CITY OF ALBUQUERQUE

March 5, 2019

Re: SAVSU
4209 Balloon Park Rd NE
30-Day Temporary Certificate of Occupancy
Transportation Development Final Inspection
Engineer's/Architect's Stamp dated 09-19-18 (E17D077)
Certification dated 2-26-19

1 G1.0a
Traffic Circulation Layout Plan
Scale: 1:200

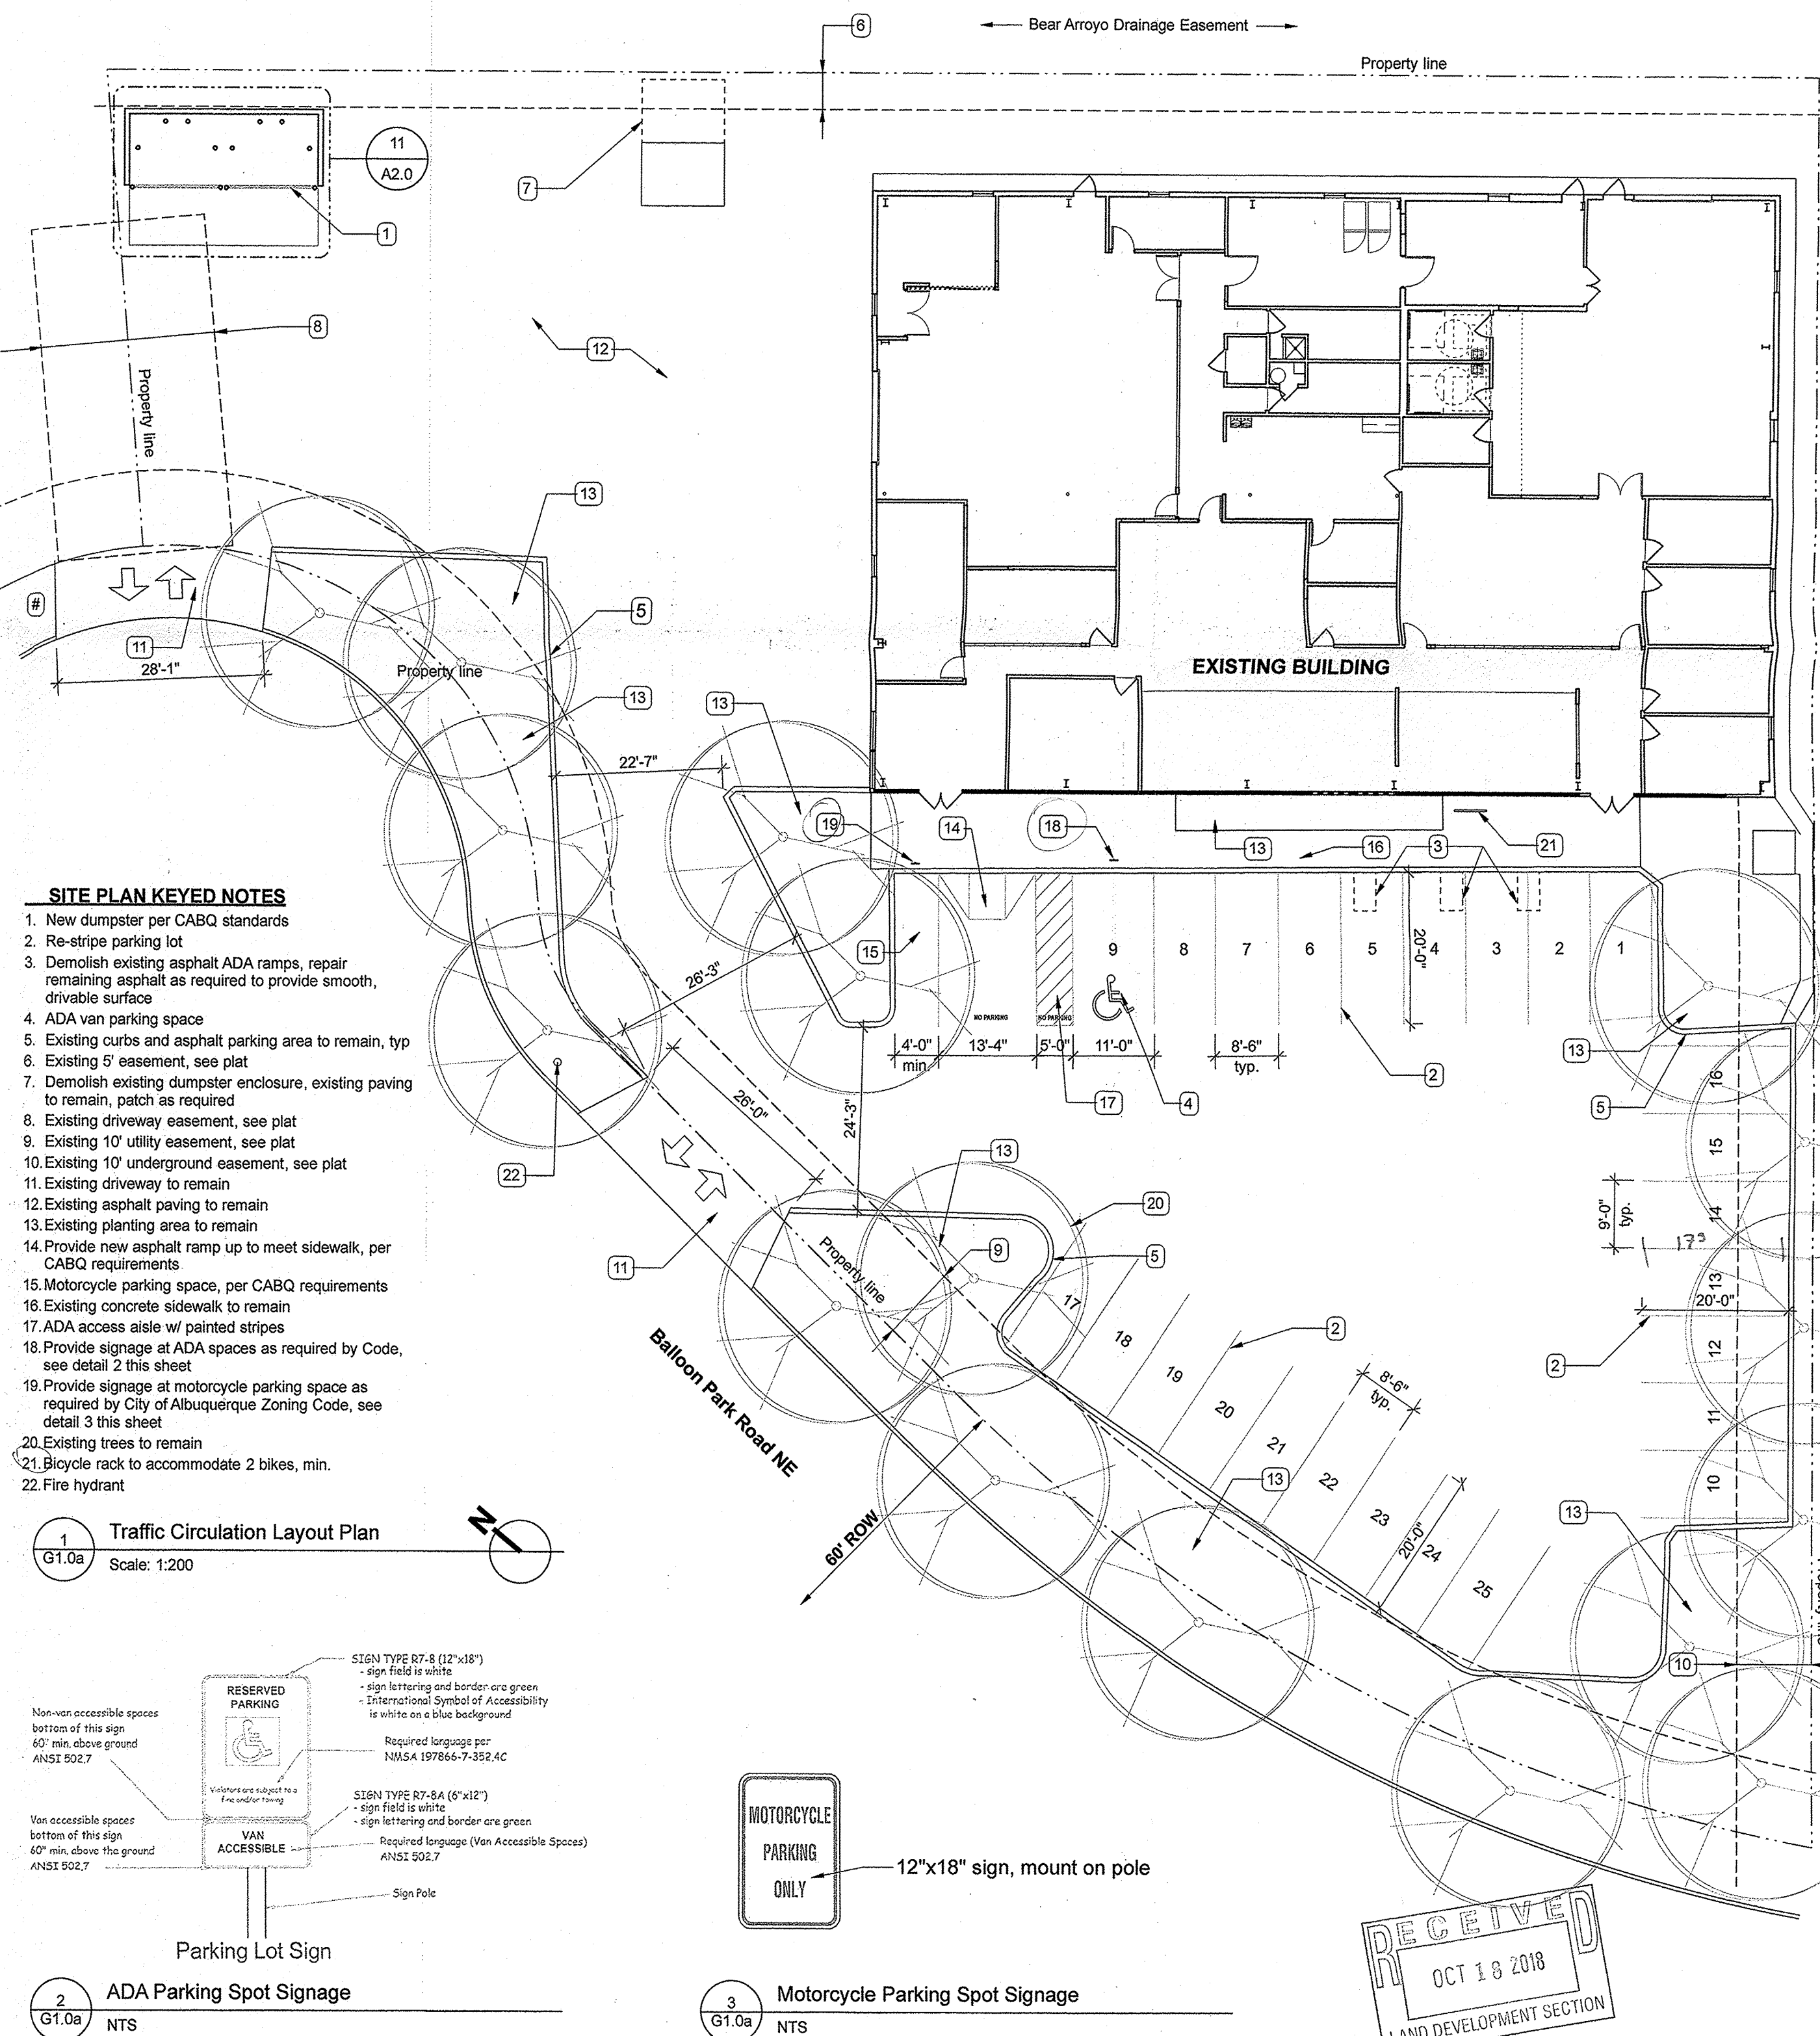
1. Please add motorcycle parking sign.
2. Please add ADA parking stall sign.
3. Please add bike rack.
4. Please add No Parking to the ADA parking access aisle.
5. Please add No Parking to space with ADA ramp. (See detail sheet)
6. Please send photos of corrections to epgomez@cabq.gov for release of final CO,
